Householder Application for Planning Permission for works or extension to a dwelling

Amendments Summary

East Elevation (Rear)

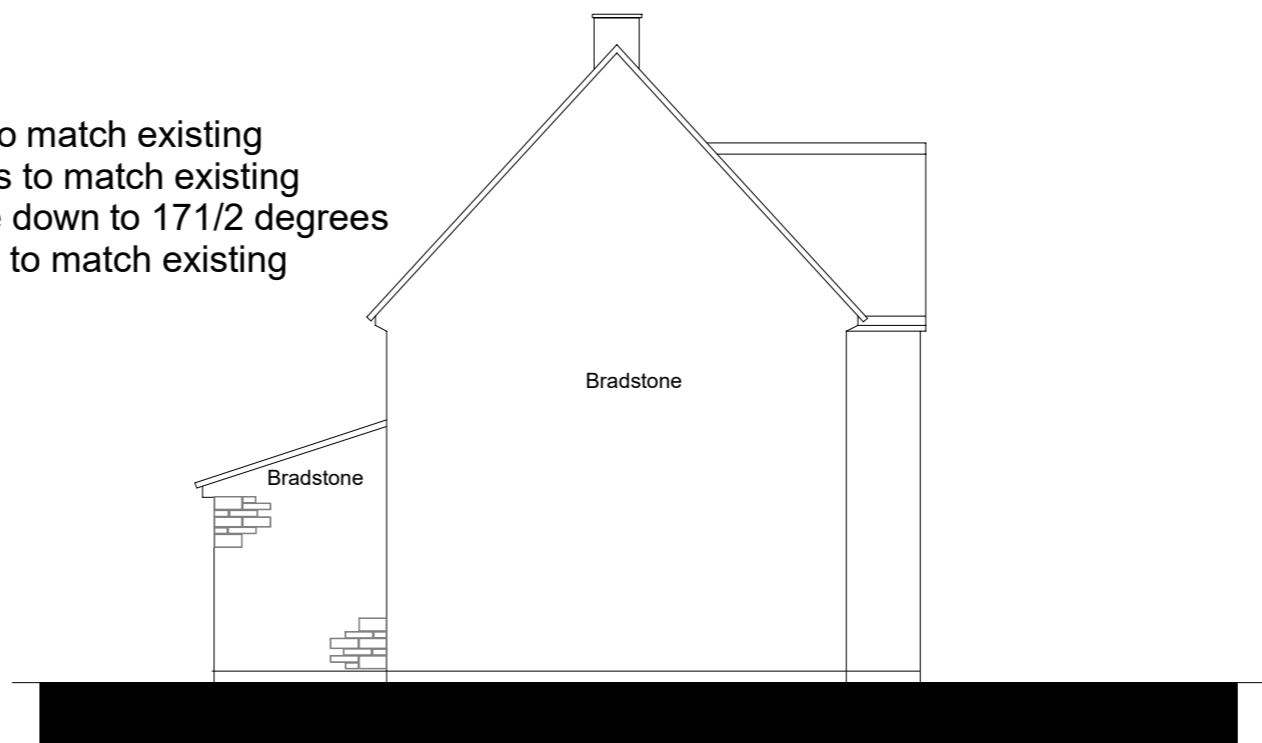
Architect forgot to add bedroom window to the east elevation (rear) 600 x 1050
